Application H14-0276-18
Location 5 BEAR LANE PINCHBECK SPALDING PE11 3XA
Proposal Erection of boundary wall

Name Mark Simmonds
Address Interim Heritage Officer

Date Submitted 17-04-18
For/Against Comments

WALL SCALE 1:50

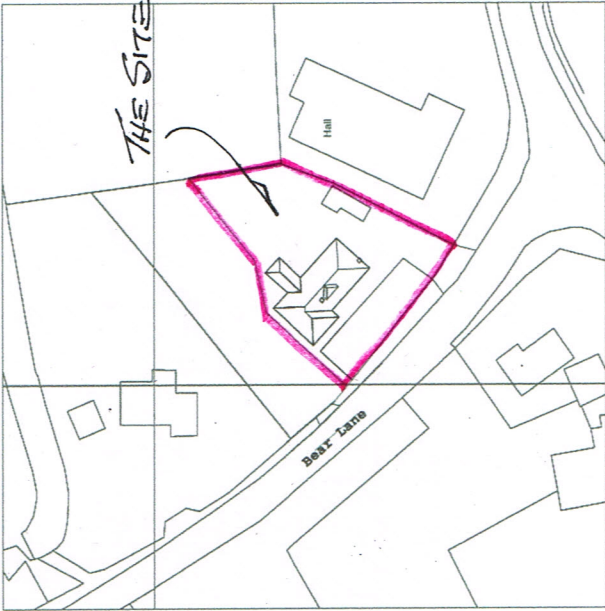
The timber element should be stained to soften the appearance.
